**From:** David Margolis-Pineo  
**To:** Helen Donaldson  
**CC:** Barbara Barhydt; DEVELOPMENT REVIEW GROUP  
**Date:** 9/9/2014 3:51 PM  
**Subject:** Pamela Road Review Comments

MEMO TO: Nell Donaldson, Planner  
FROM: David Margolis-Pineo  
DATE: September 9, 2014  
RE: Pamela Road Extension, Final Level II Site Plan Application

**The Department of Public Services has the following comments.**

TYPICAL ROAD CROSS SECTION
NOT TO SCALE

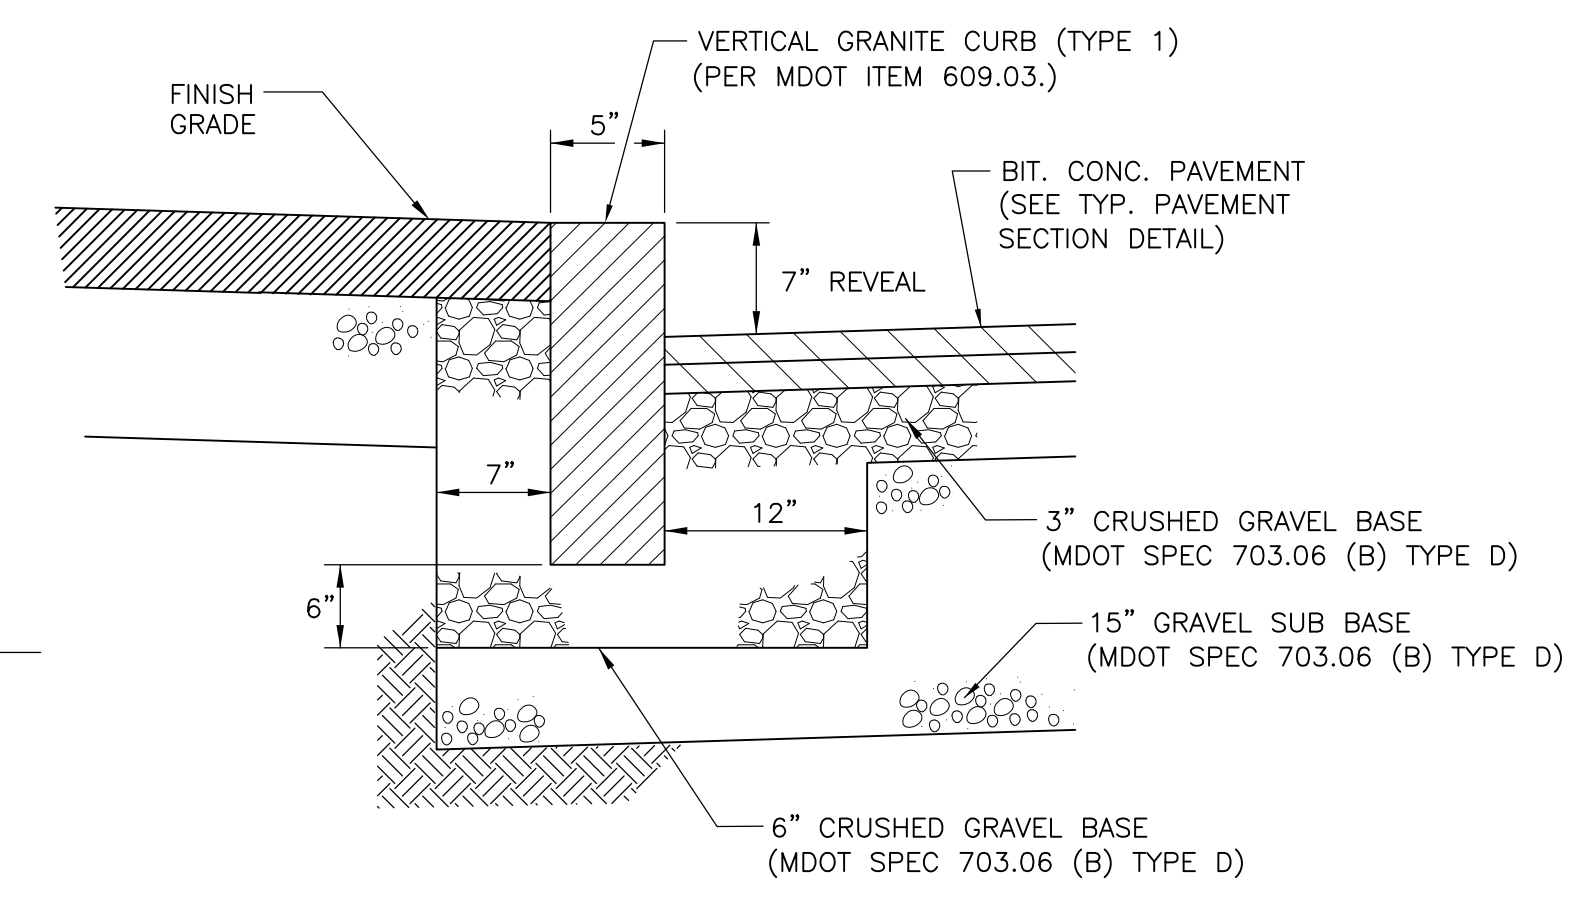
- 1. As noted by Woodard and Curran, the applicant is failing to meet the City's Technical Manual standards for catchbasins design and castings.** If not already on the plans, please add a general note stating that "All proposed infrastructure located within the road right of way shall meet City of Portland Technical Manual standards."

PER MDOT ITEM 604.15  
**PRECAST CONCRETE DRAIN MANHOLE**  
 N.T.S.

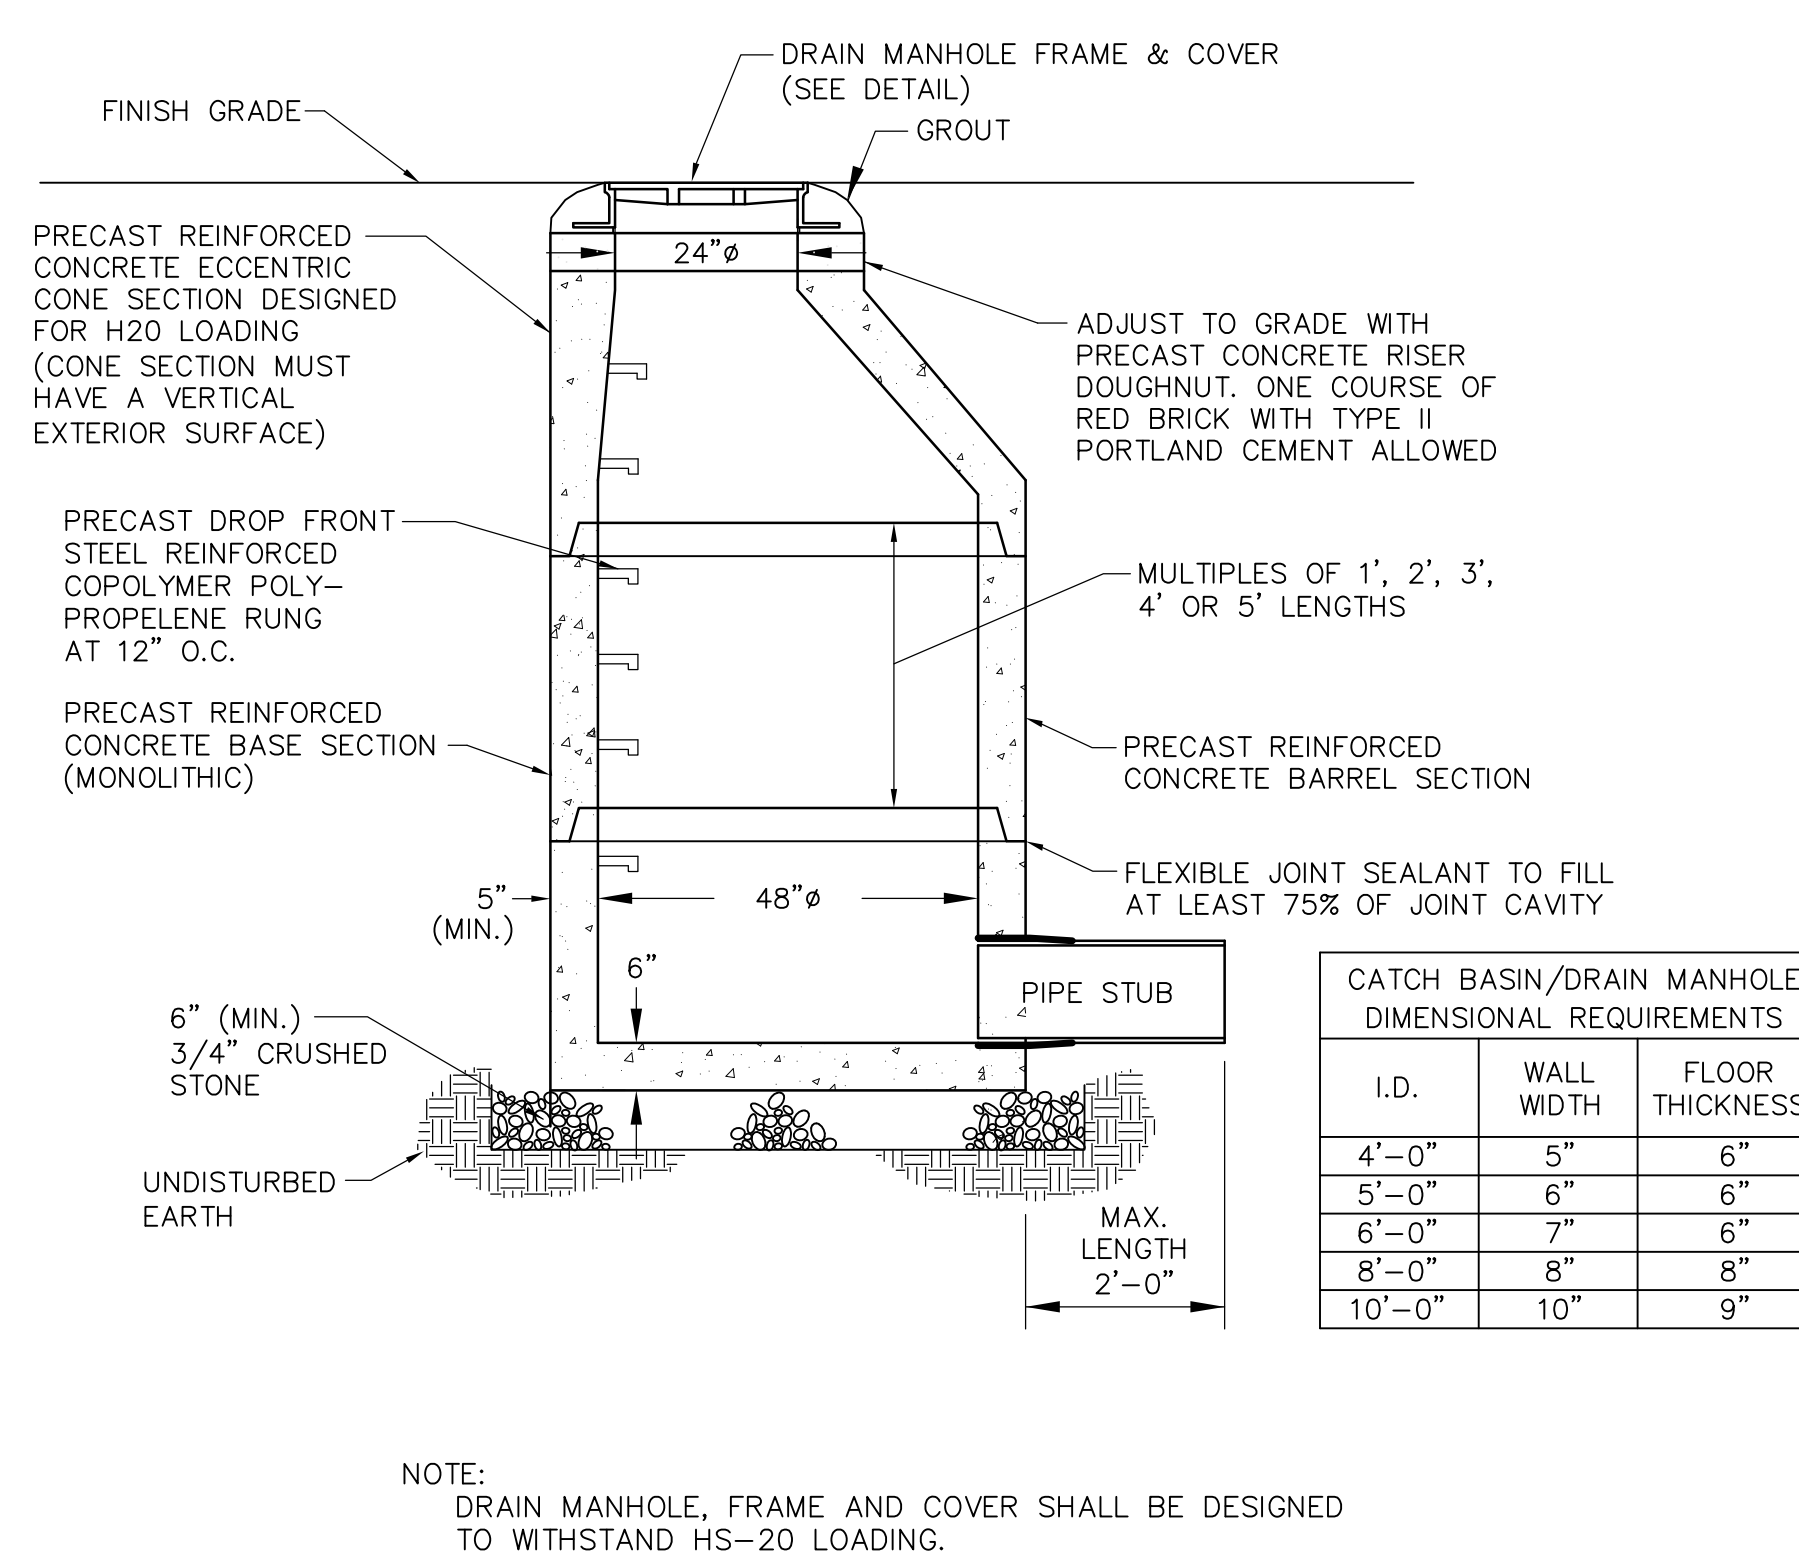
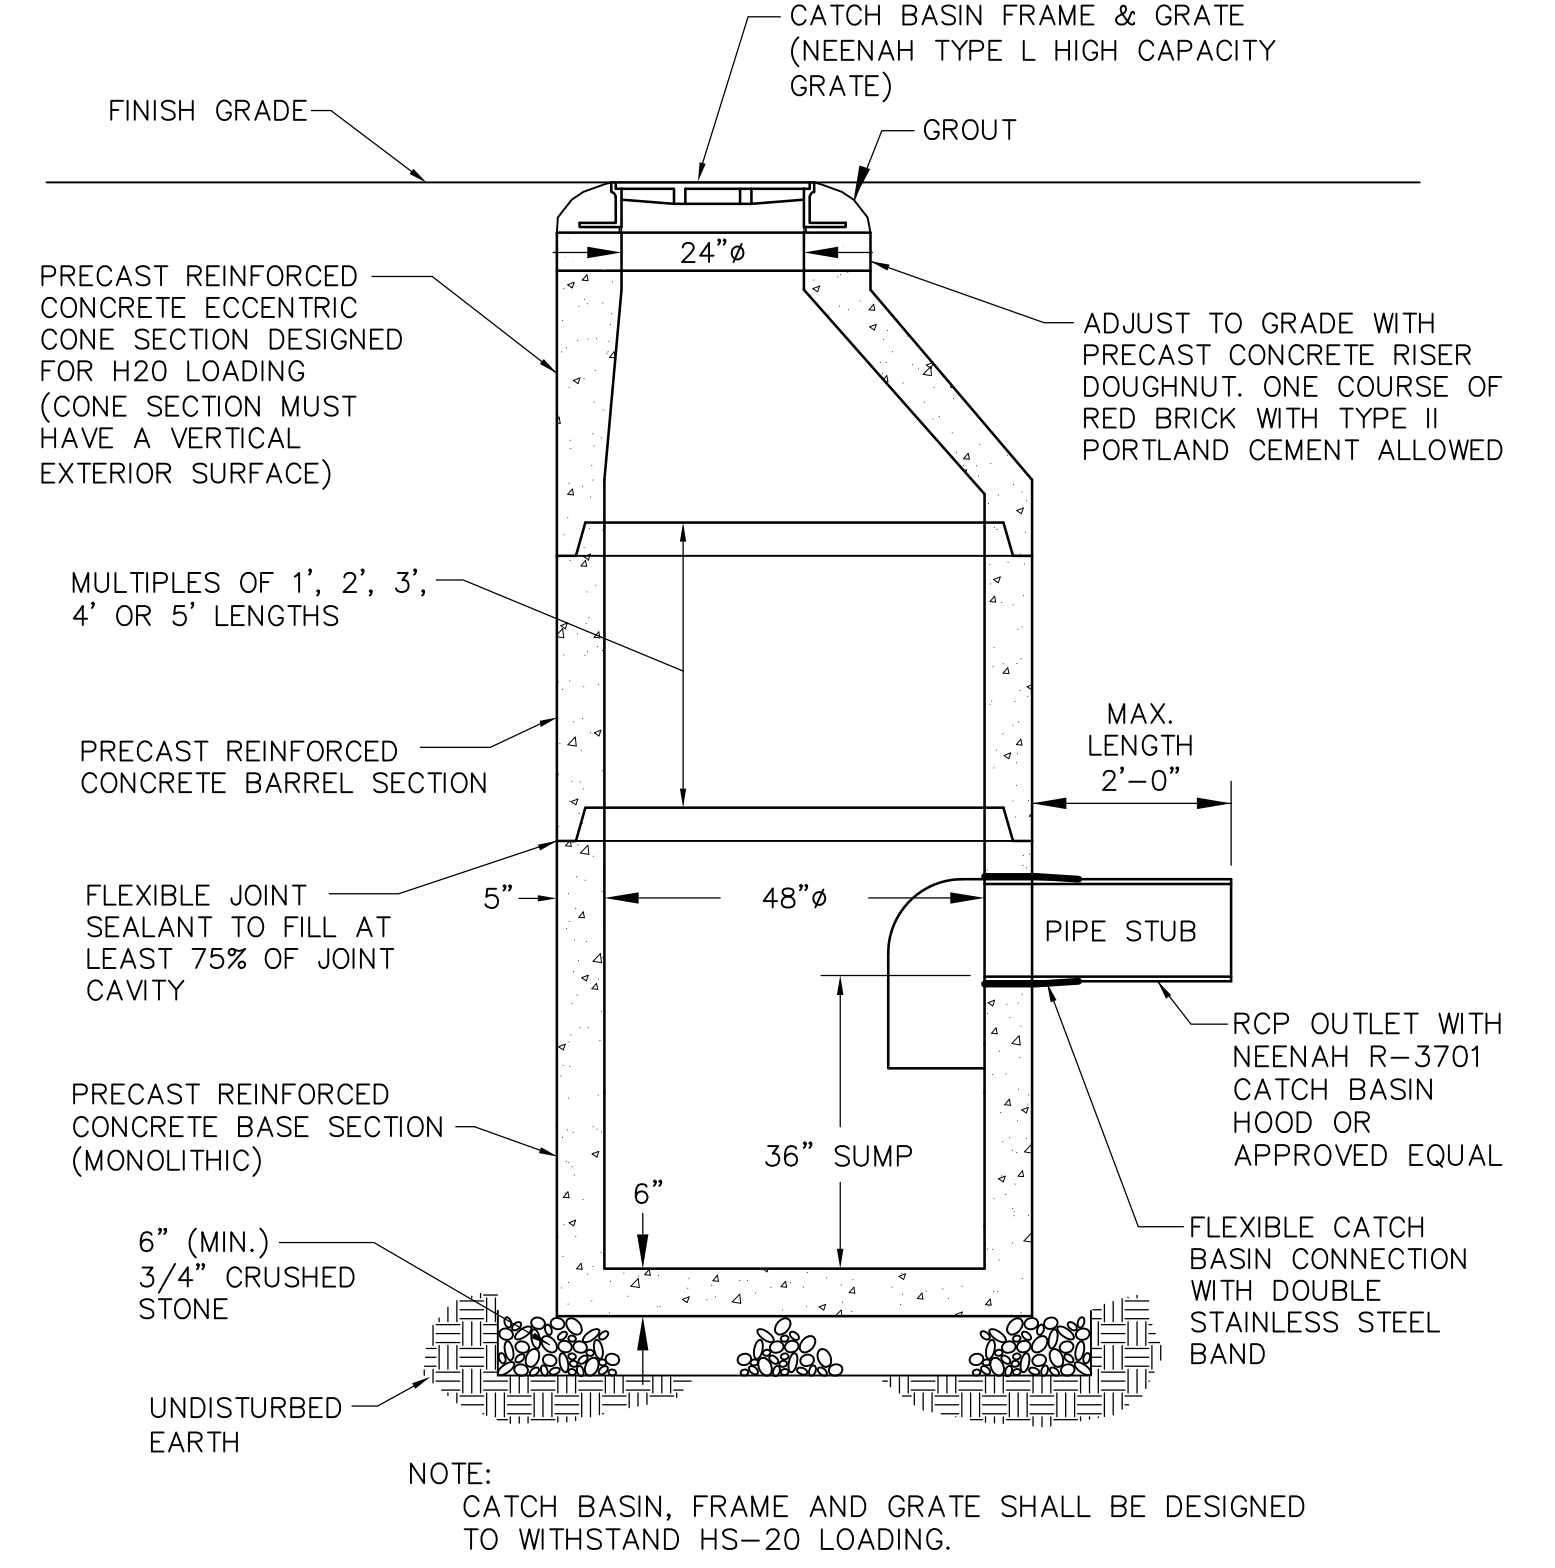
- 4. Please provide a detail of the drain manhole to be installed in Alice St.**

Drawing Name:
GRADING & DRAINAGE PLAN

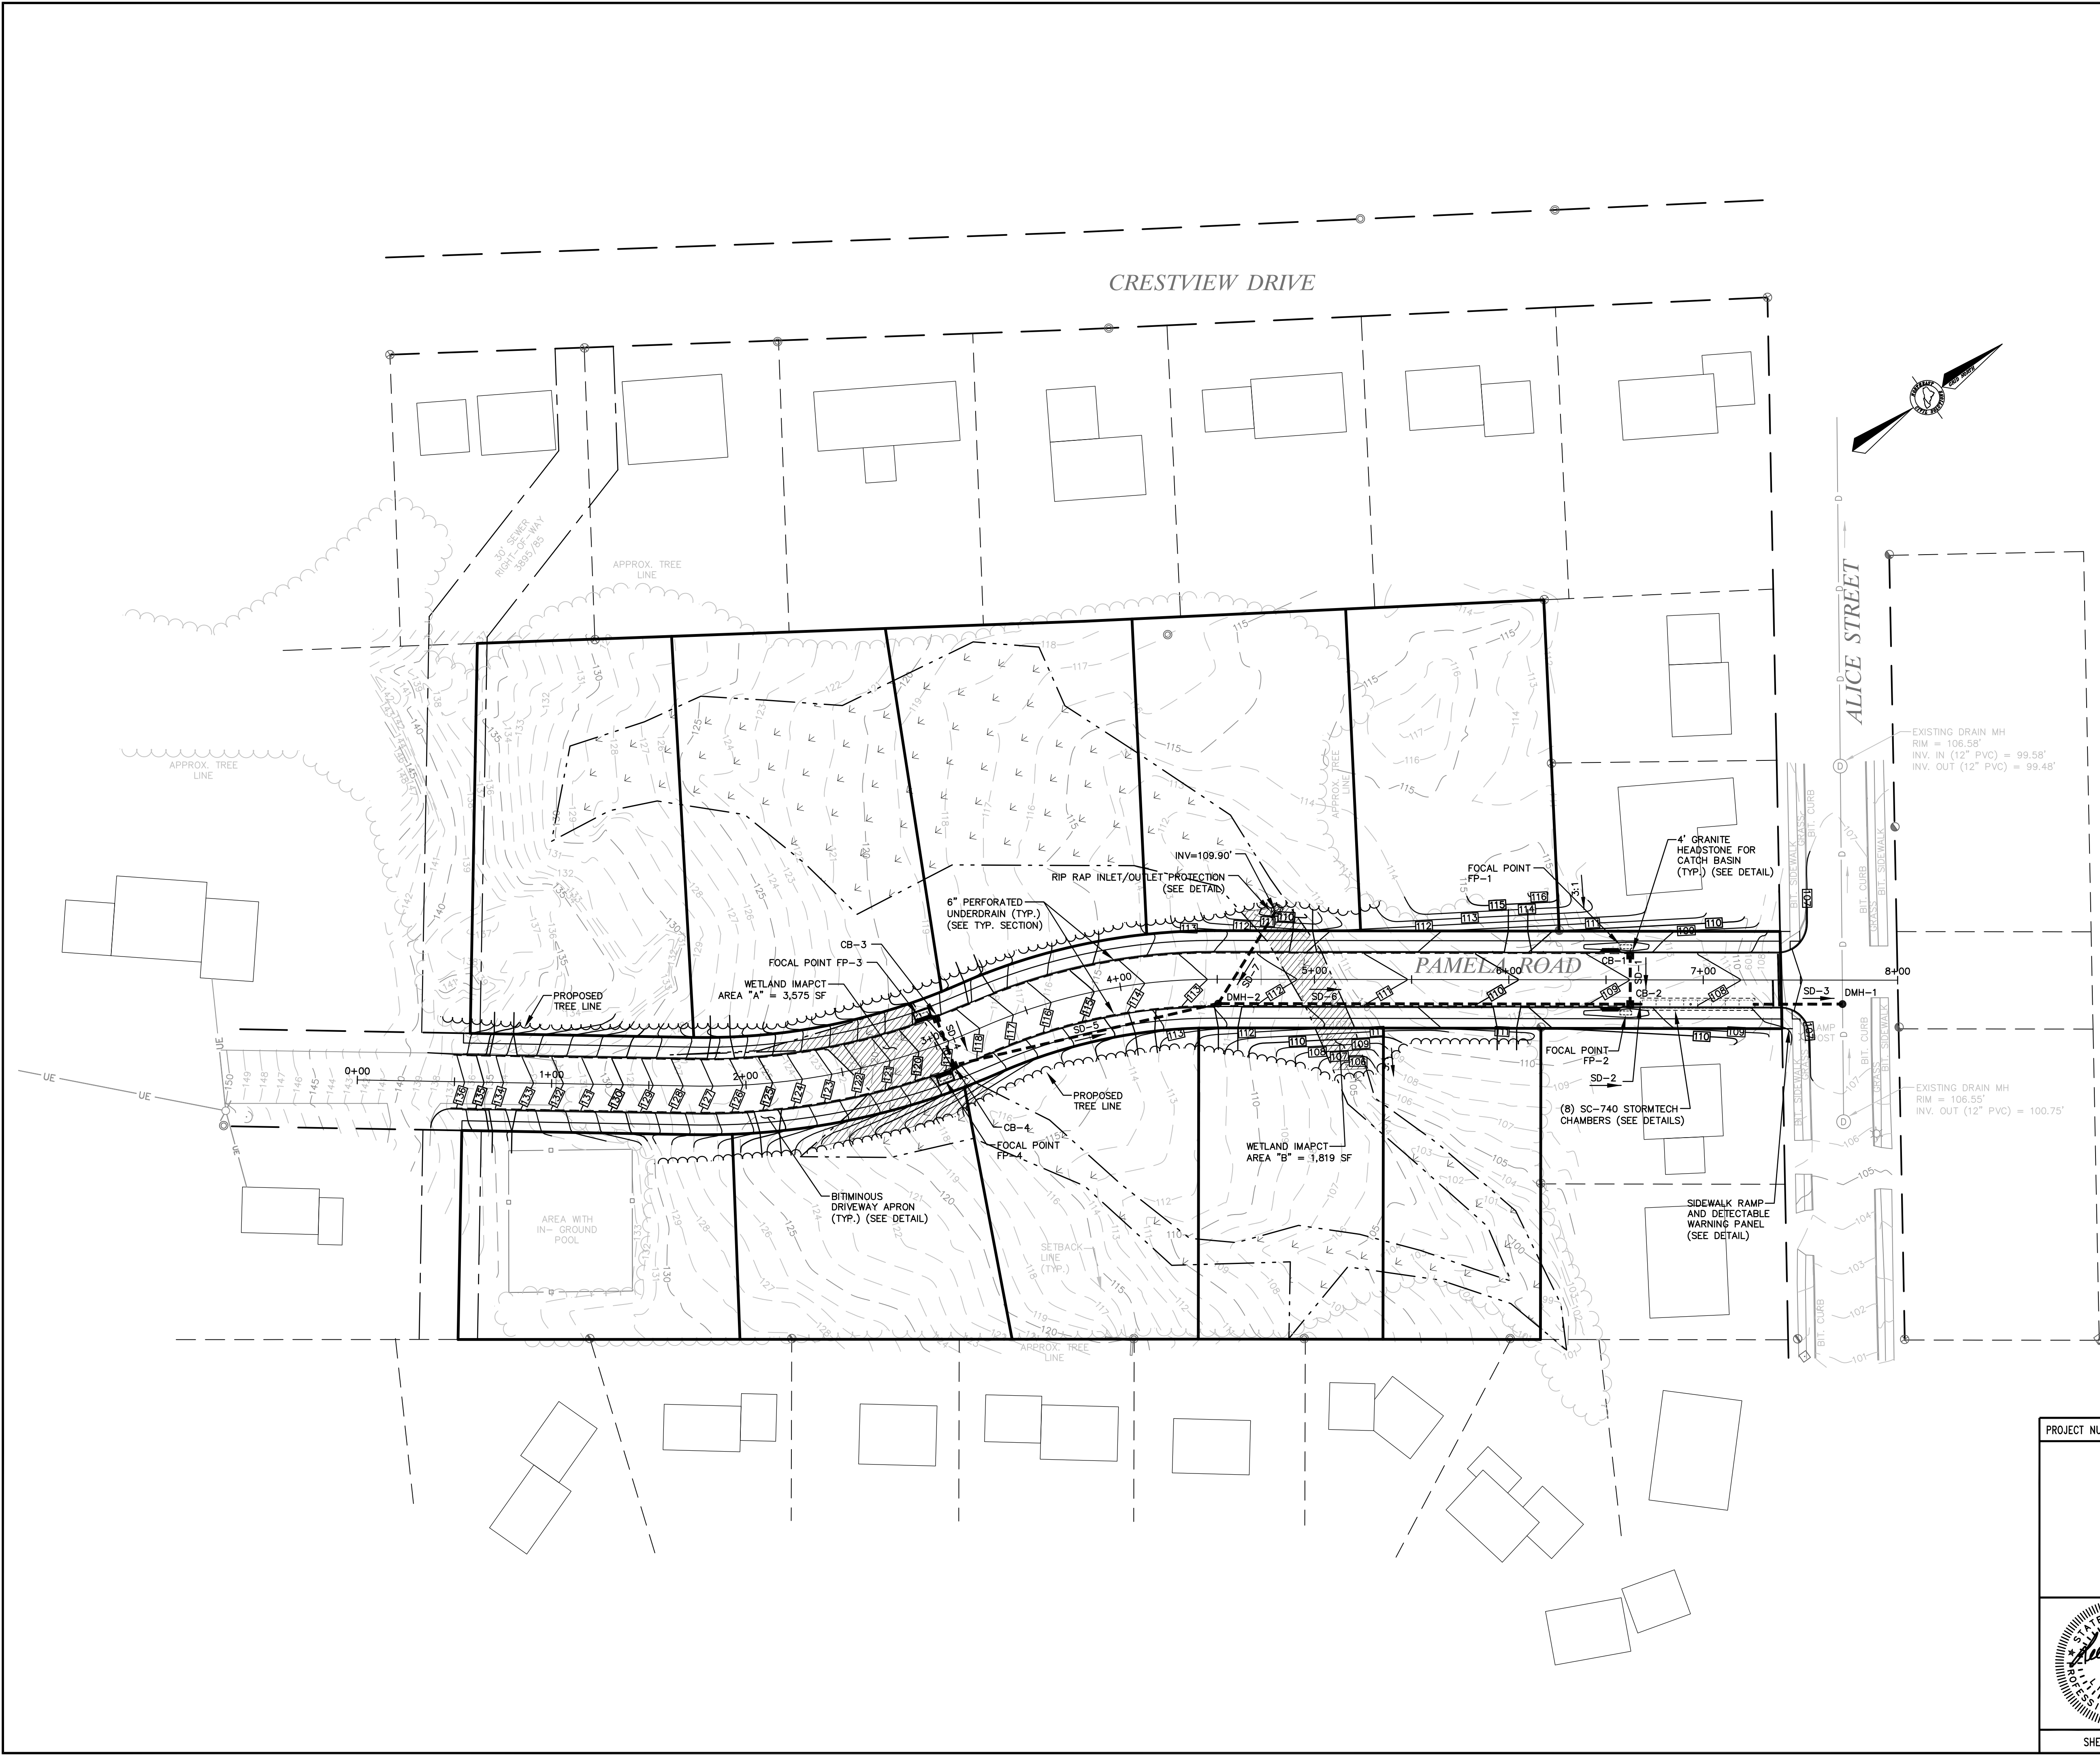
- 3. The roadway surface area being drained to proposed catch basin's one and two is quite large.** We are requesting the applicant place two additional basin at approximate station 3+00. We would also like the applicant to consider an alternative catchbasin casting (not the City standard) to increase gutter drainage capture due to the street grade. This could be a rectangular type casting by Neenah with a "L" or scoop style design.
